Your Ref: OWPC23743
Our Ref: K/19/19/HH 25-06-2019
Please ask for:
Zac Denton

Two storey rear extension with a small canopy projecting the footprint to the front.
Demolition of existing living room and additional first floor for habitable use with
alterations to fenestration.

Little Tangley Middle Way Kingston Gorse East Preston

Thank you for your internet representation made on 23rd July 2019 which has been recorded
as '**an objection**' with the comments as follows:

Proposed Ground Floor Plan

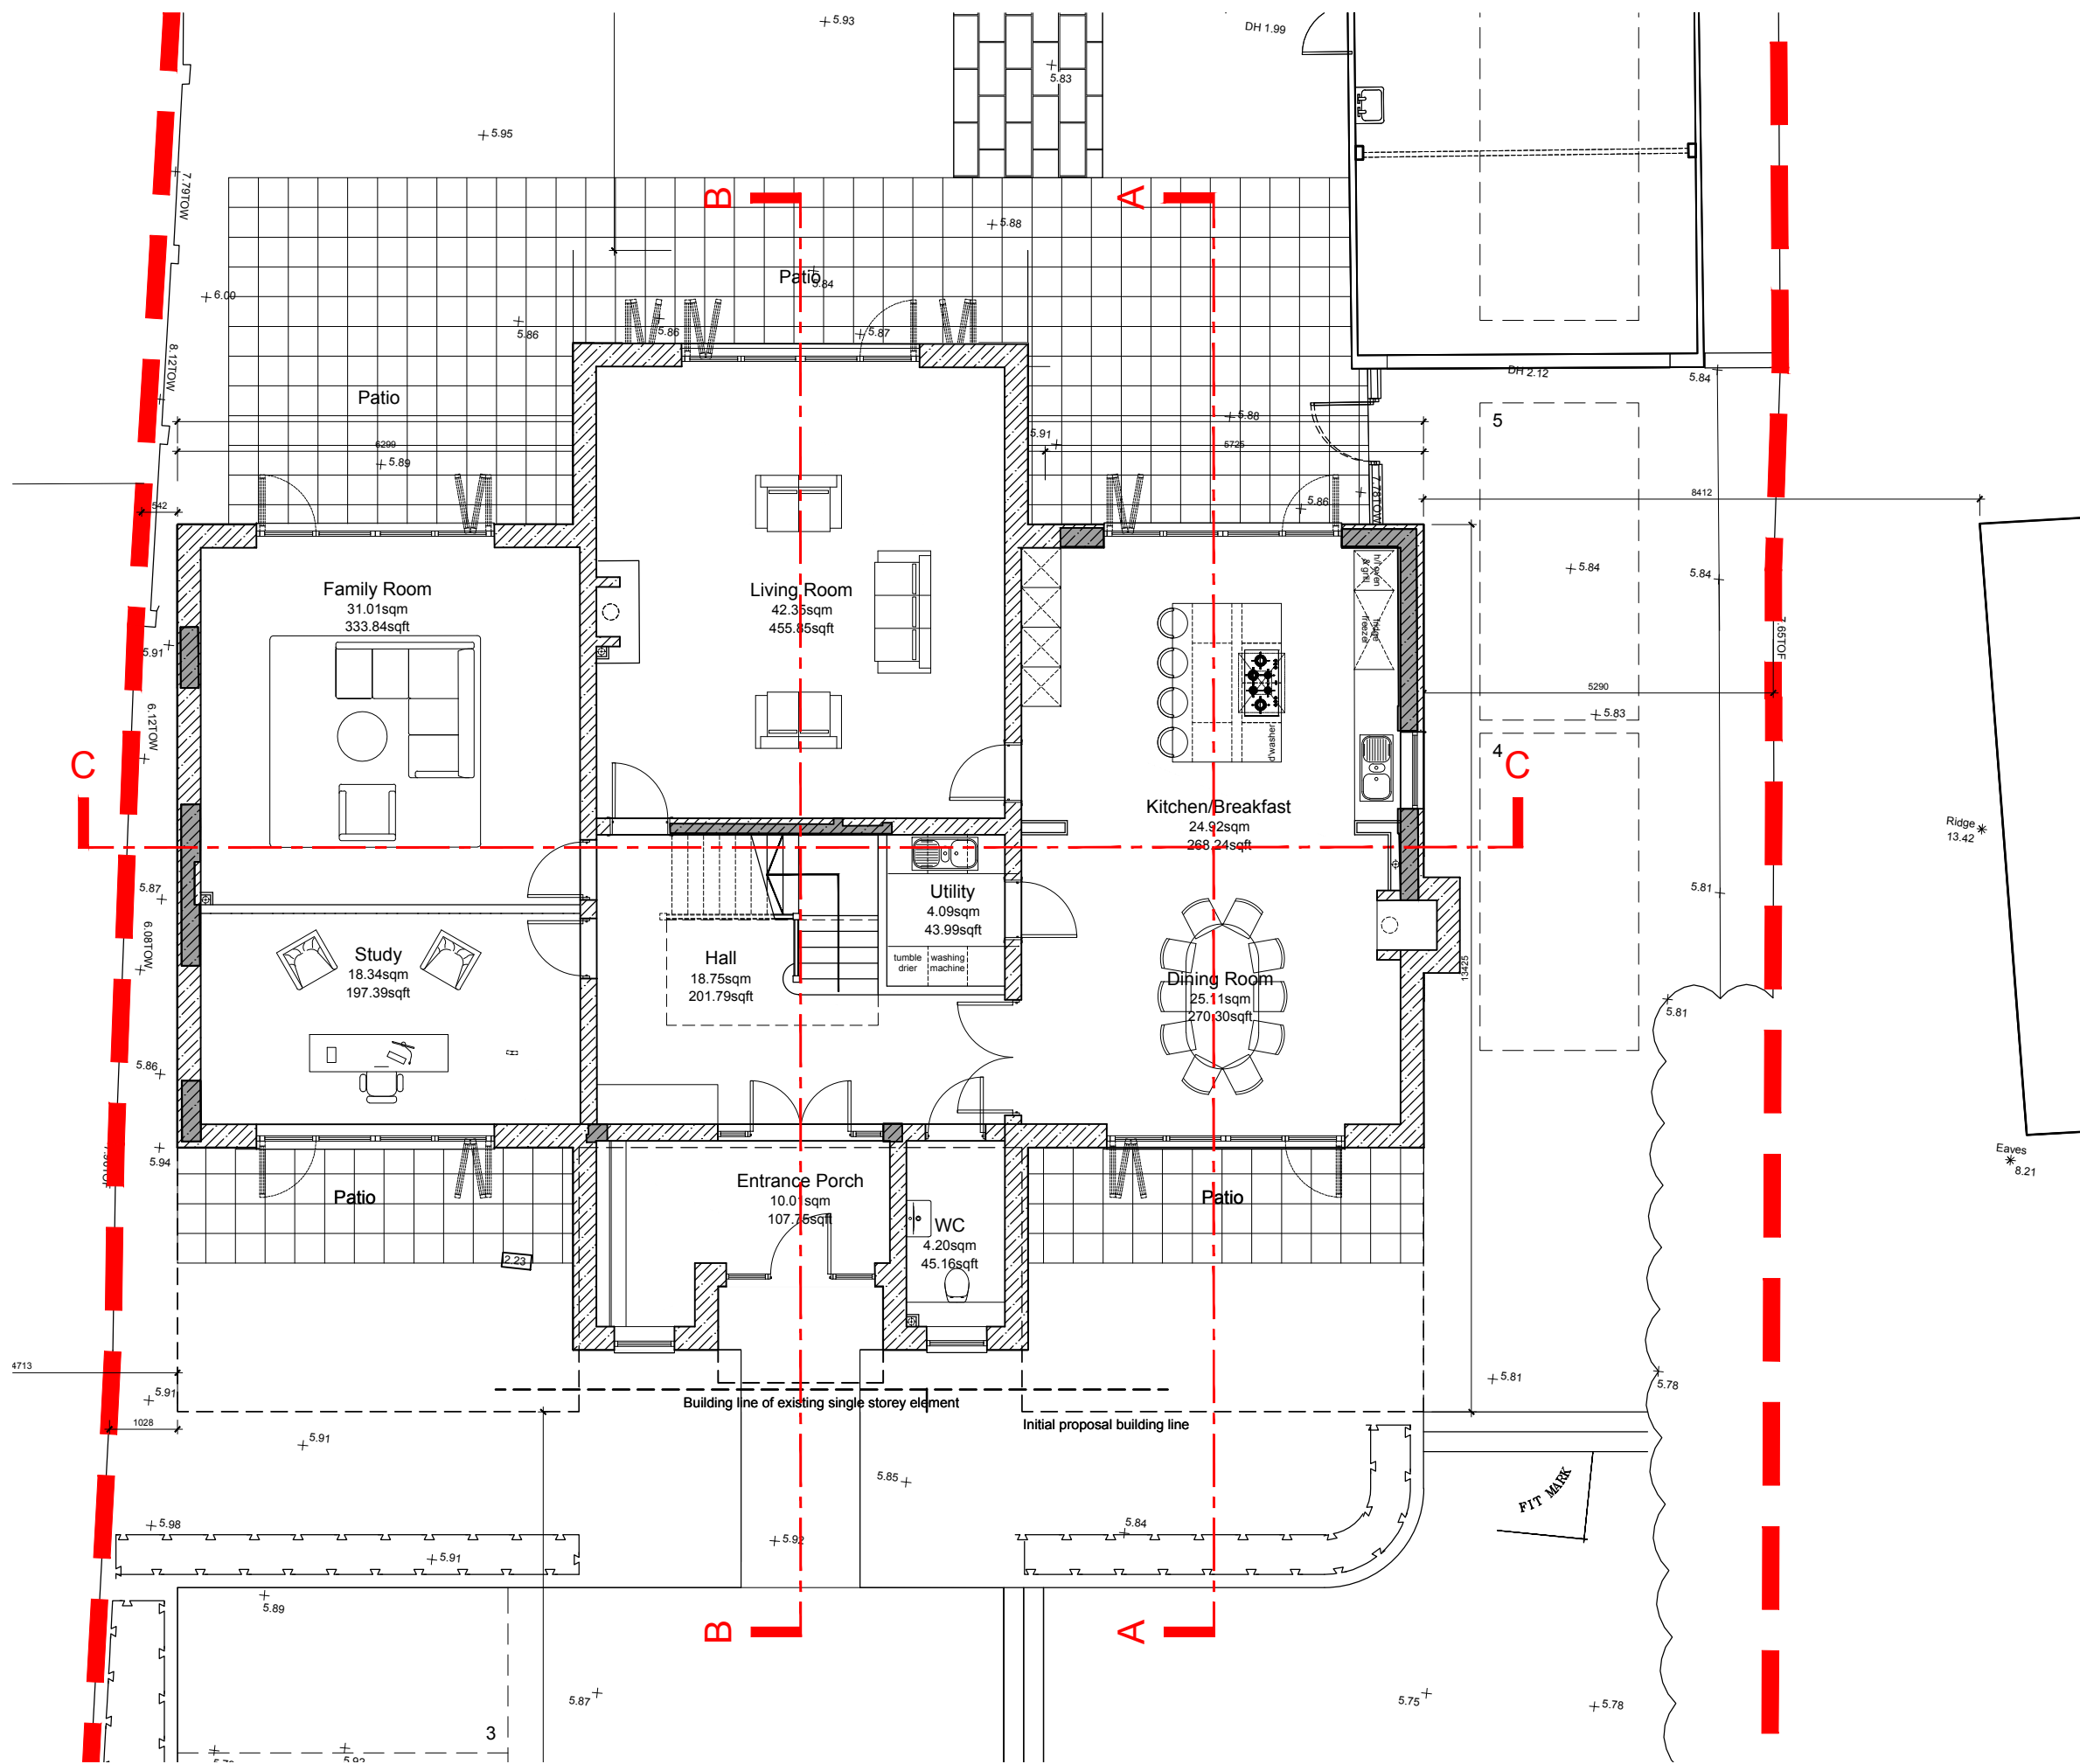
The proposal for this to be replaced by a so-called "small canopy" - a two storey entrance with a porch/hallway, a fifth bedroom immediately above, and a gable extending almost to the full ridge height - will substantially and adversely impact on our light. The proposed two-storey western flank and gable will be directly in the line of our kitchen window, to the south of the original line of the bungalow.

Unlike any other house in Middle Way, including Little Tangley, Clova only has a garden to the south (ie. between the road and the house). At present, as we relax in and enjoy our garden, we are not overlooked at all by the occupants of Little Tangley, but under the proposal for a front upper storey "small canopy", within the footprint of the current single storey sunroom, we would be overlooked from the first floor window of the proposed fifth bedroom. We consider this would be intrusive and would have a material impact on our privacy.

Drawing Title
Proposed Sections

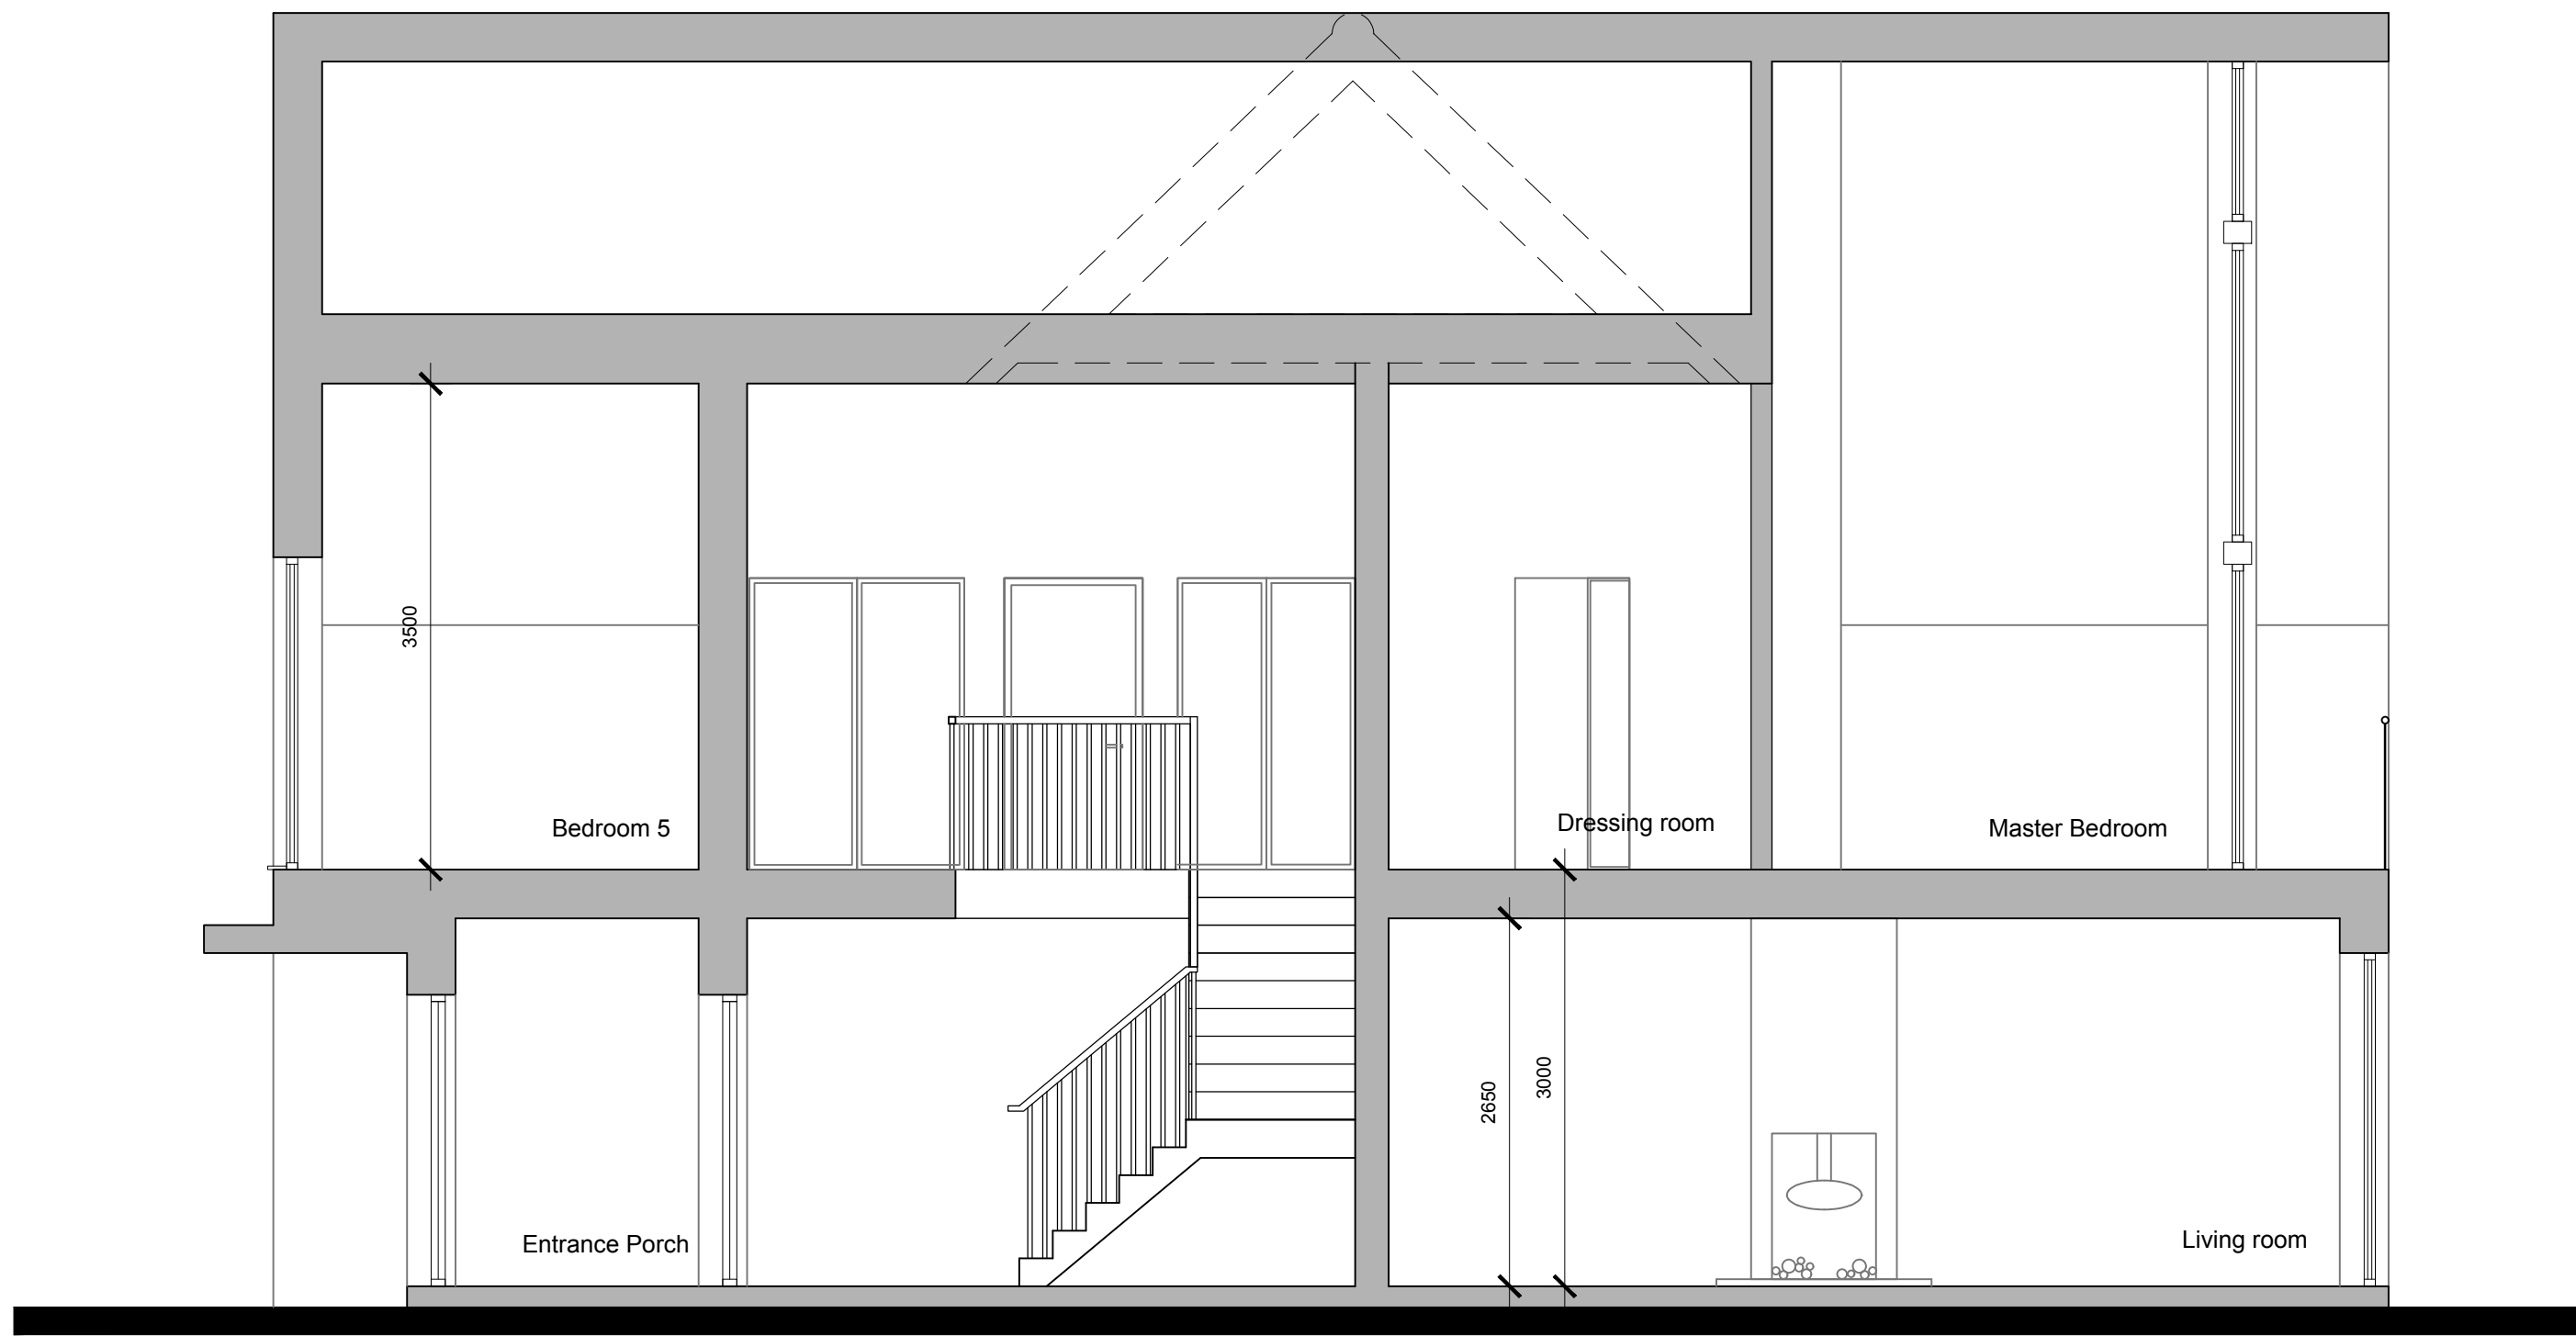
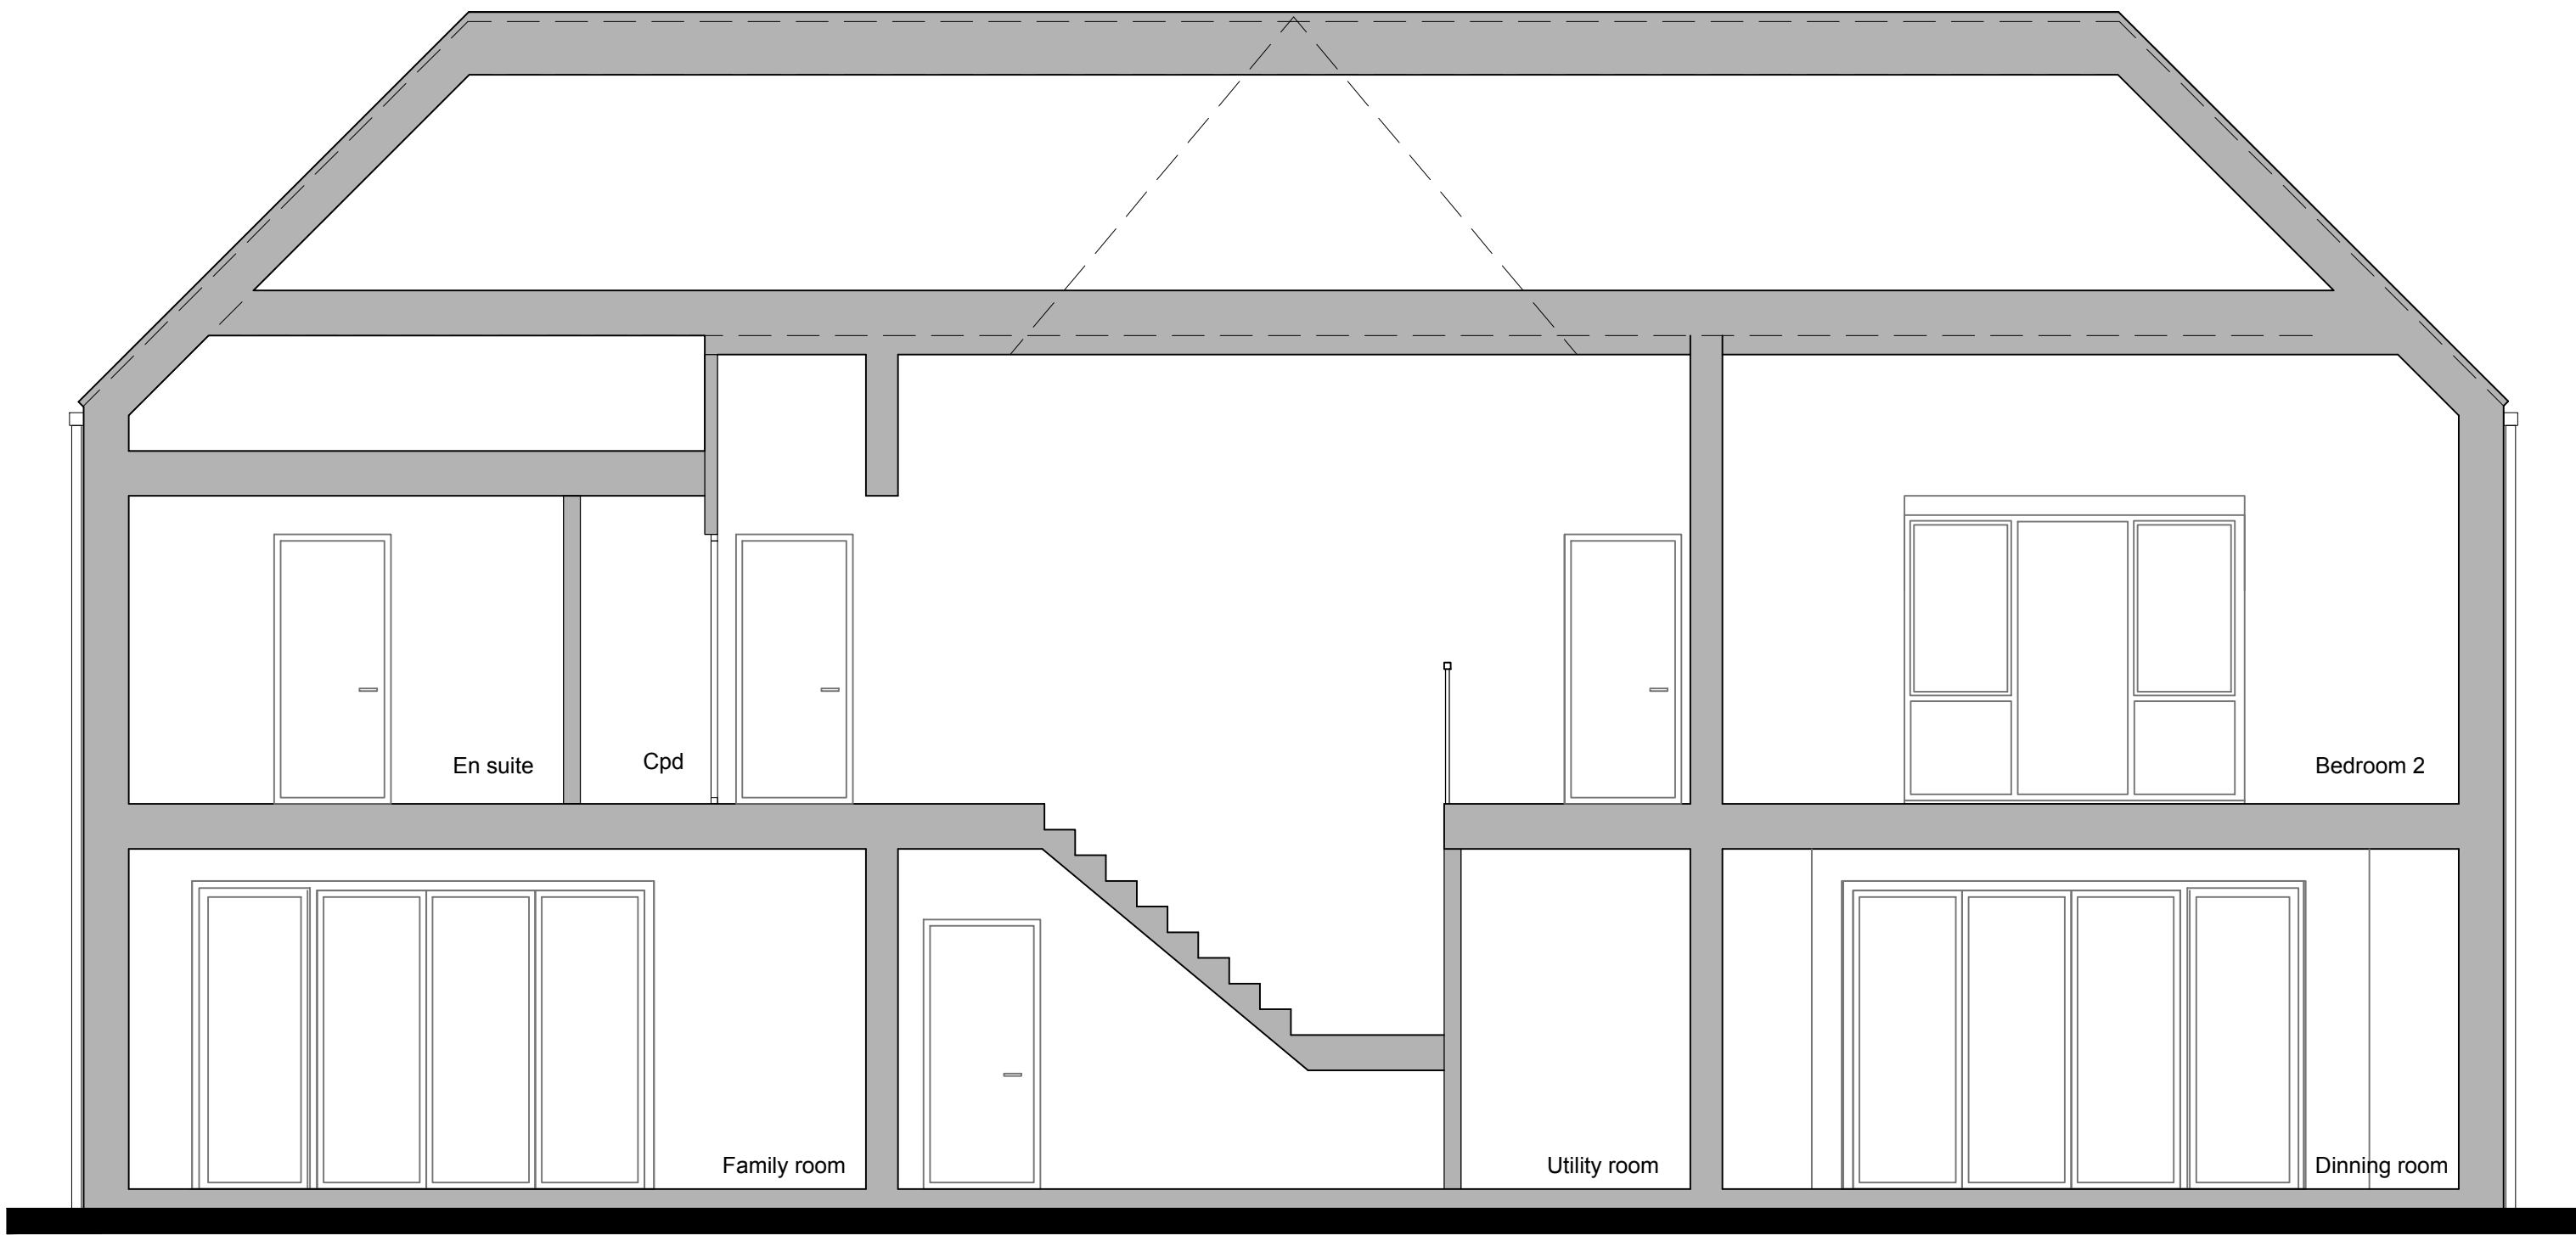
*The existing chalet bungalow is essentially a single storey dwelling with one bedroom in
the roof. The proposed development, which is somewhat coyly termed an "extension" by
the applicant but is effectively the construction of a new house, seeks to increase the
overall mass of the property by more than 200% with a substantial increase in
accommodation to five bedrooms and a very significant raising of the ridge height. We
believe this constitutes overdevelopment.*
